Your Ref :
Our Ref : LU/368/14/NMA

**Section 96A of the Town & Country Planning Act 1990 (as amended)
Town and Country Planning (Development Management Procedure) (England) Order 2010 (as amended) - Article 9**

**Application for a Non-Material Amendment following a grant of planning permission LU/517/04 for revisions to block A elevations to show change of materials to elevation.
26-30 Surrey Street, Littlehampton, .**

Dwg No
A 217 112 F

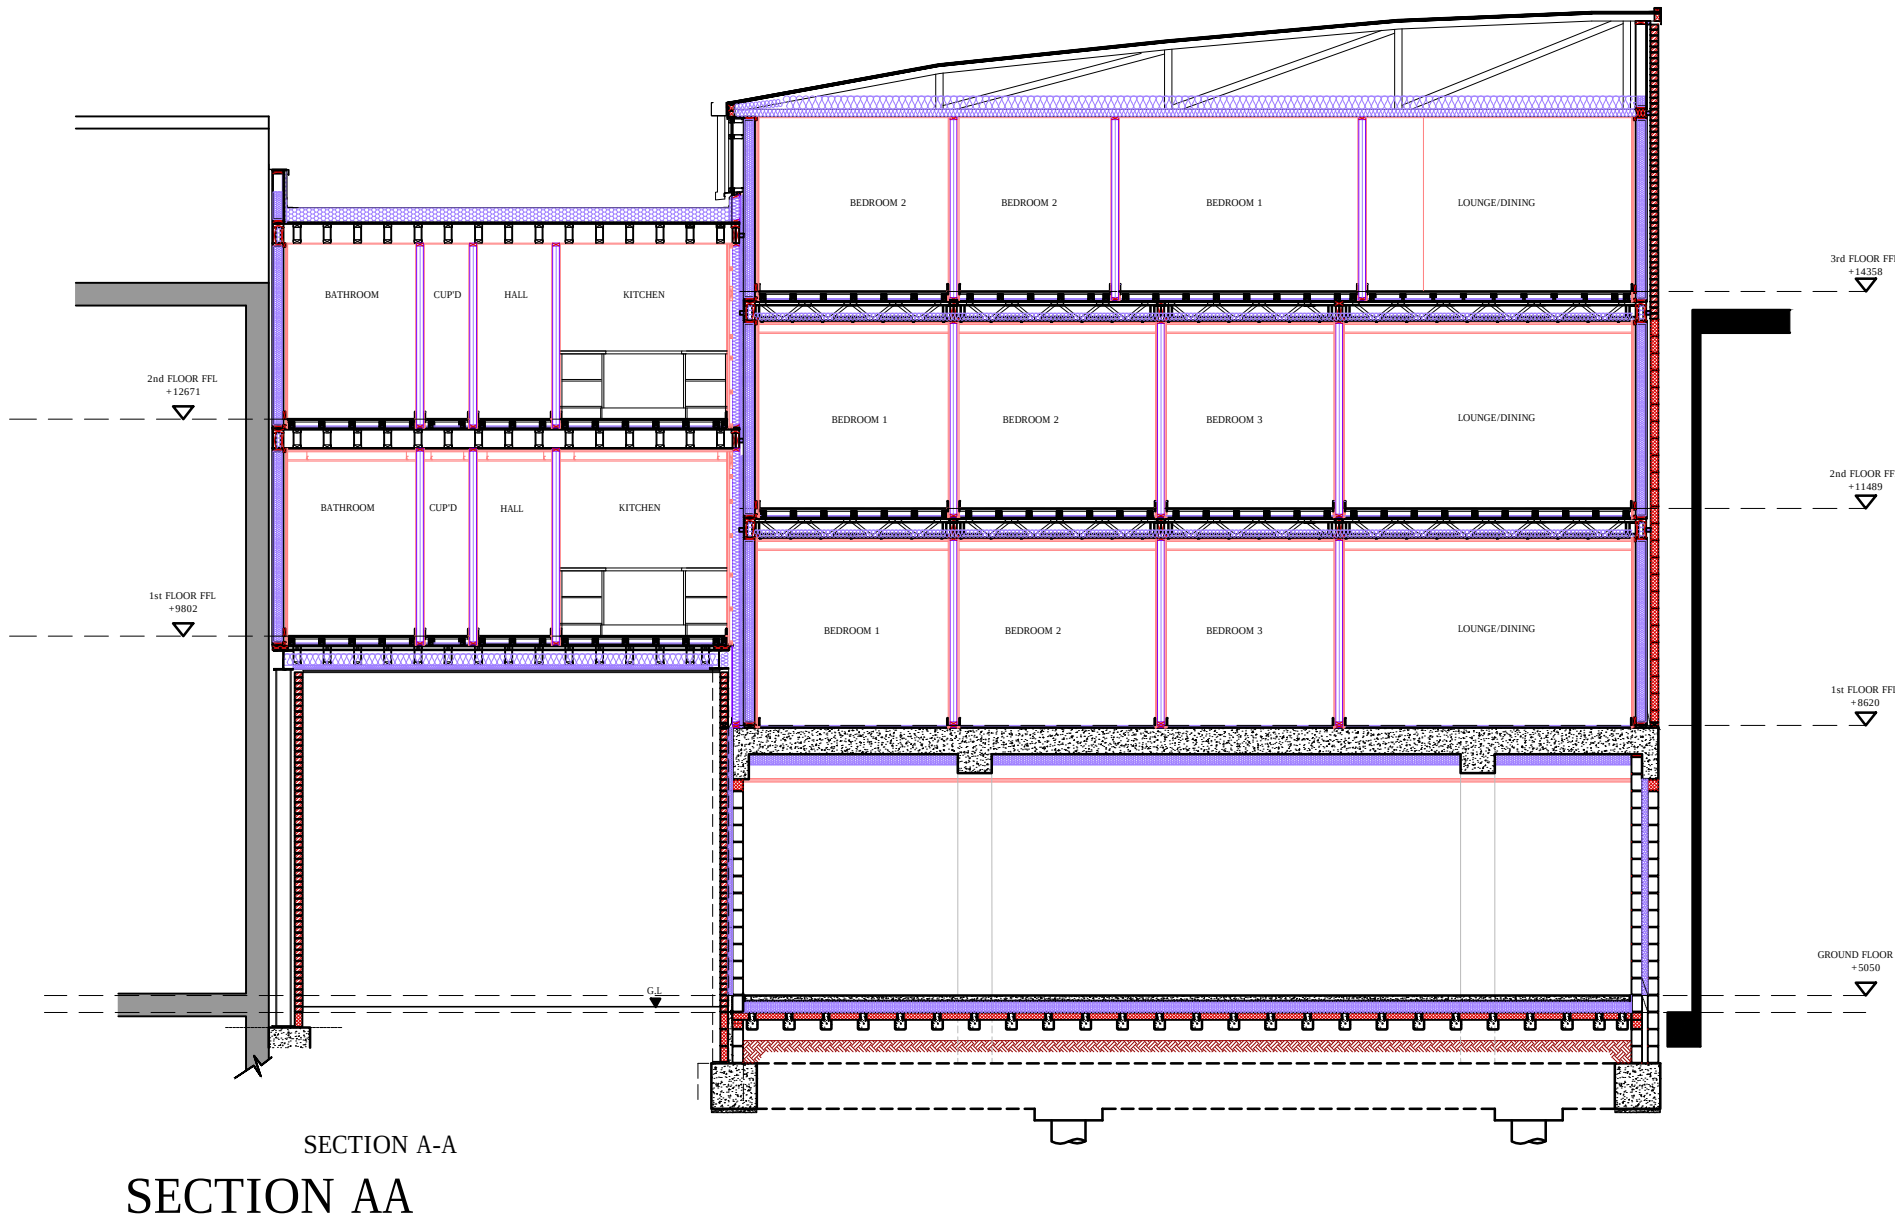
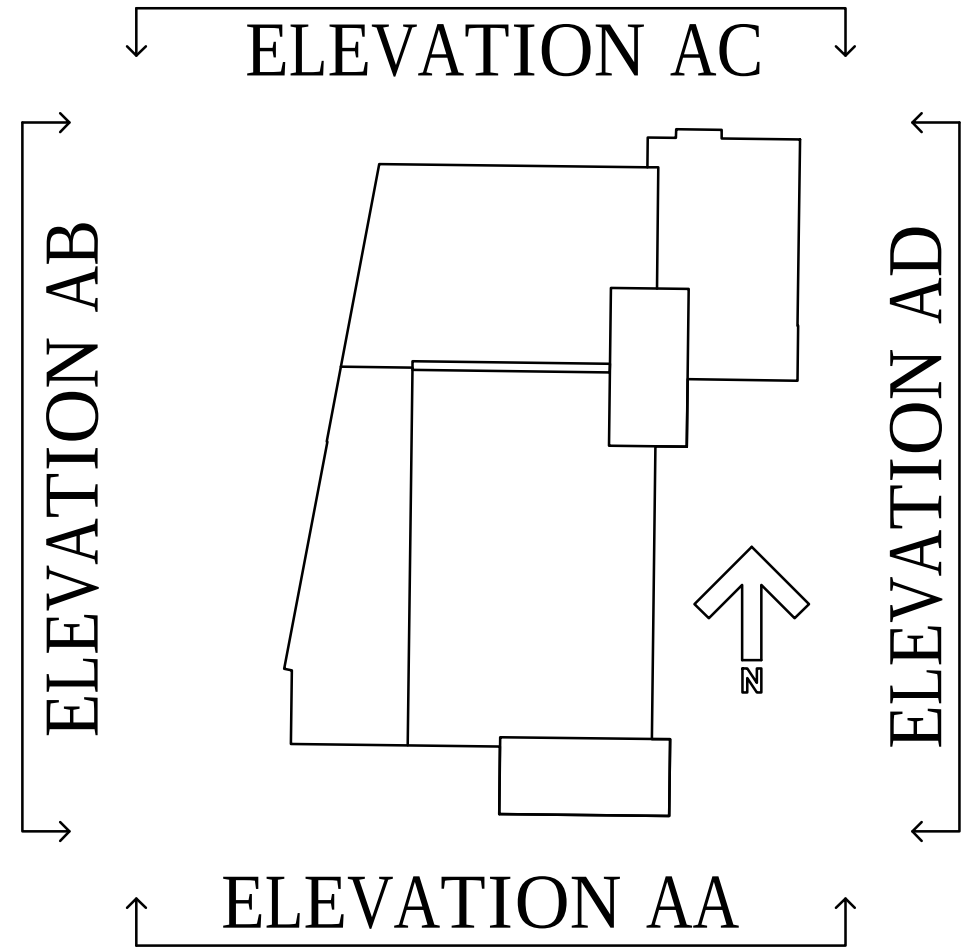
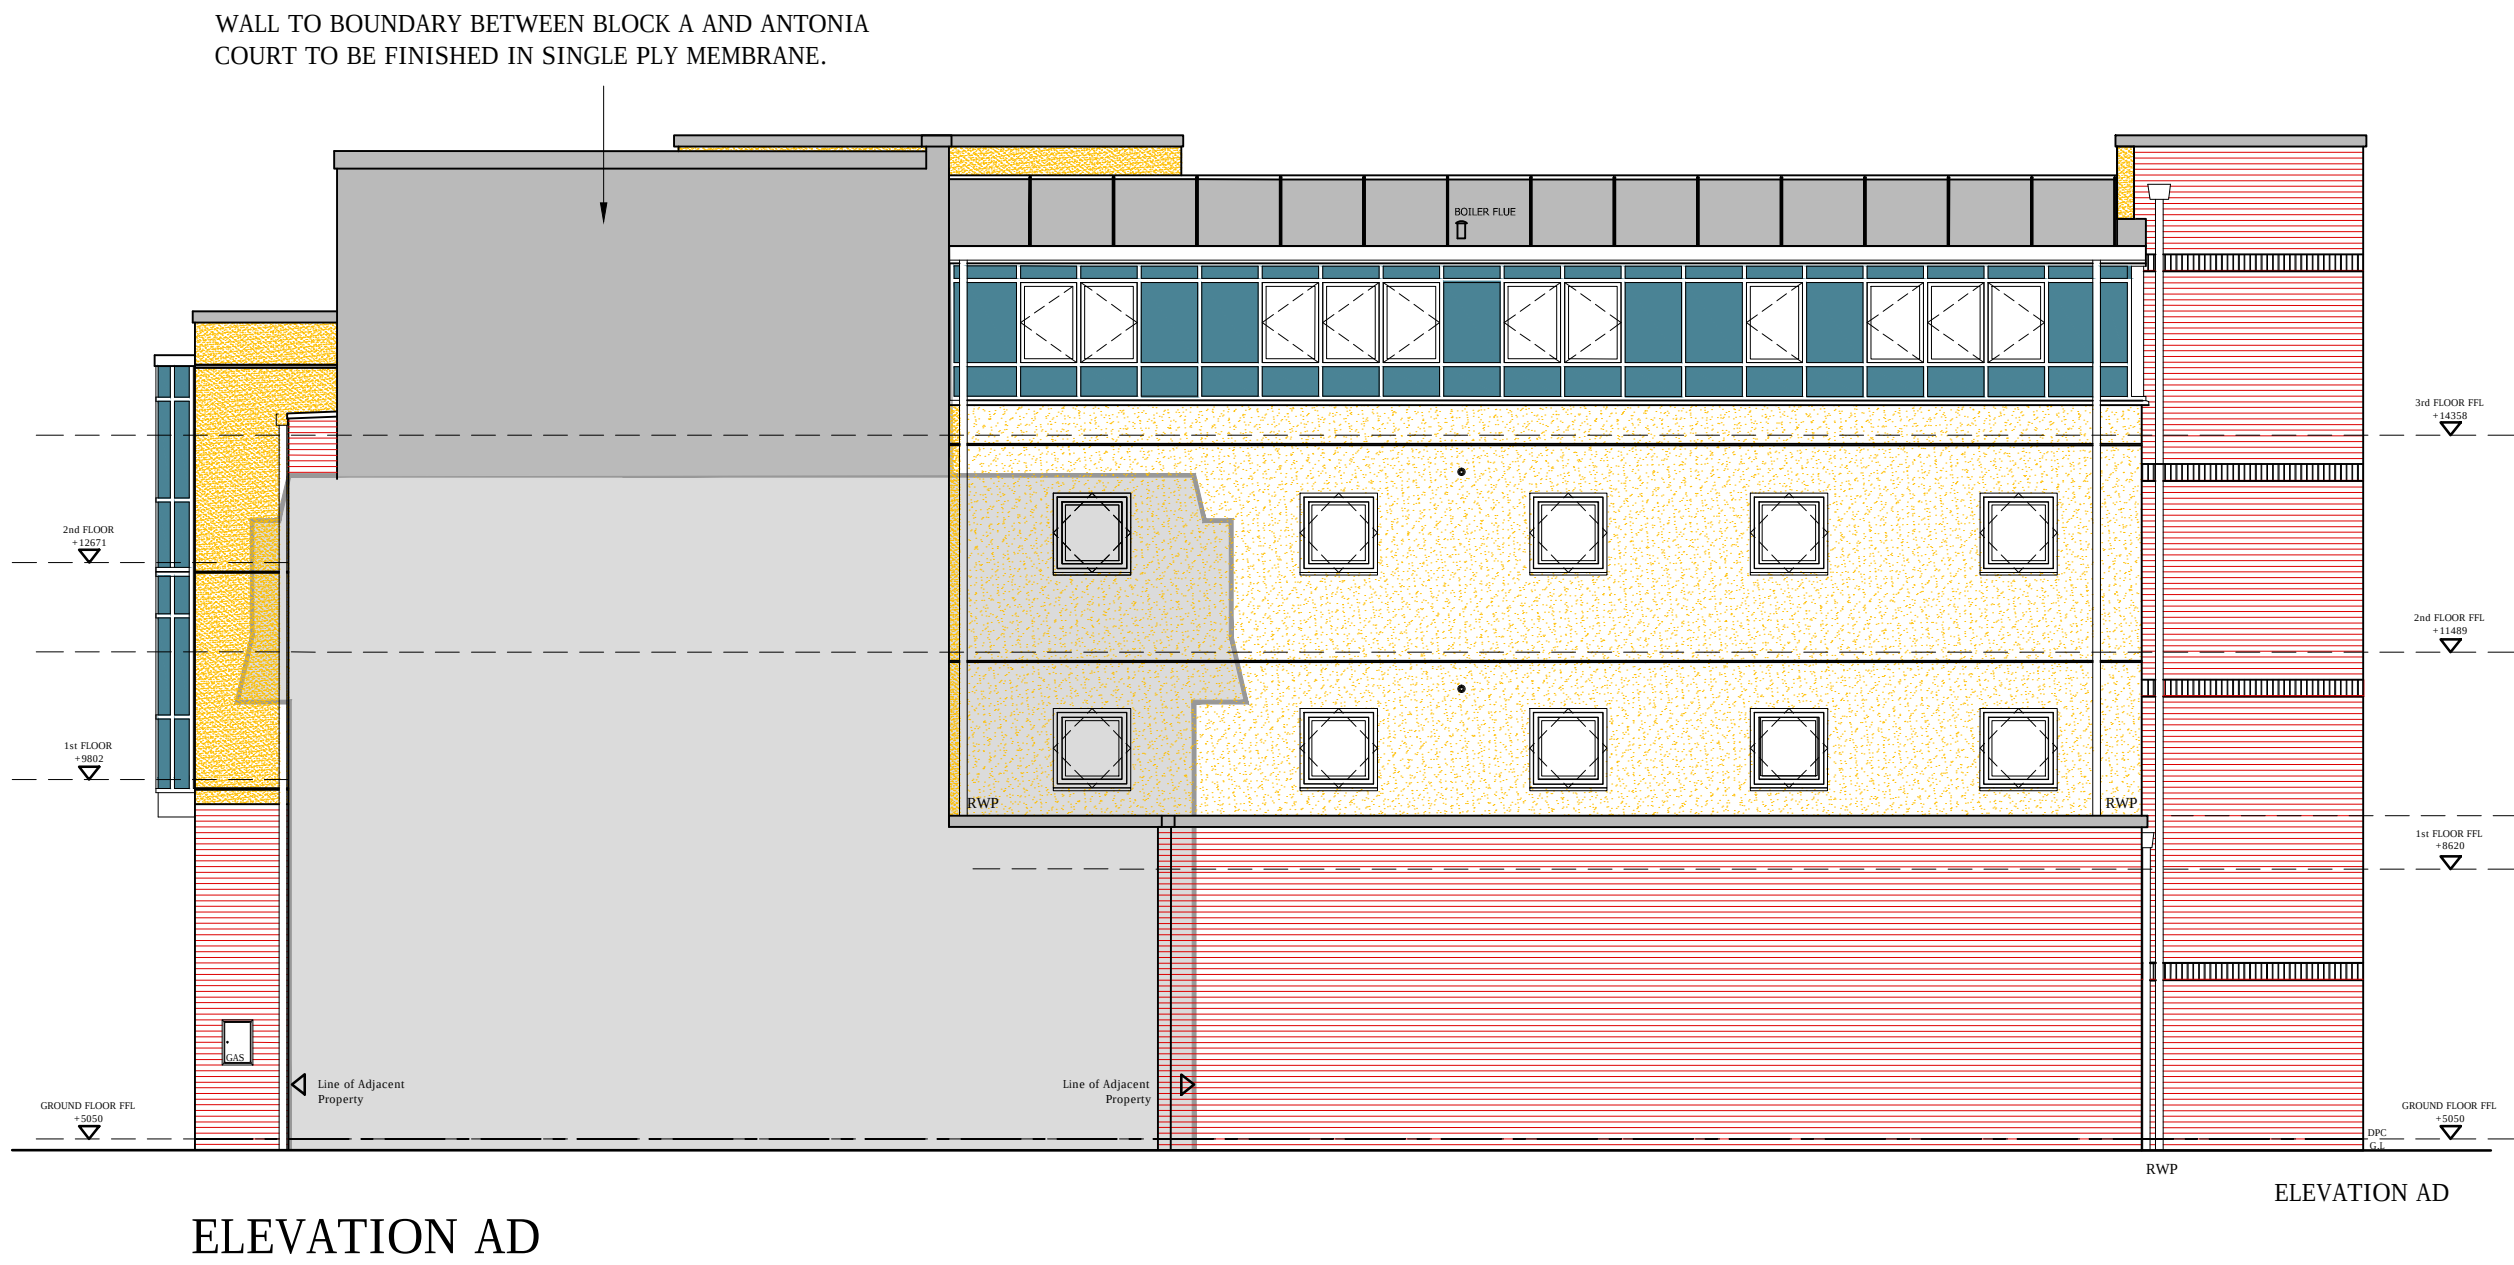
I refer to your recent application for a Non Material Minor Amendment. From the information submitted I am of the view that the change in material to part of the west elevation of block A, as shown on drawing No. A 217 112 Revision F, can be accepted as a non-material amendment to the approval.
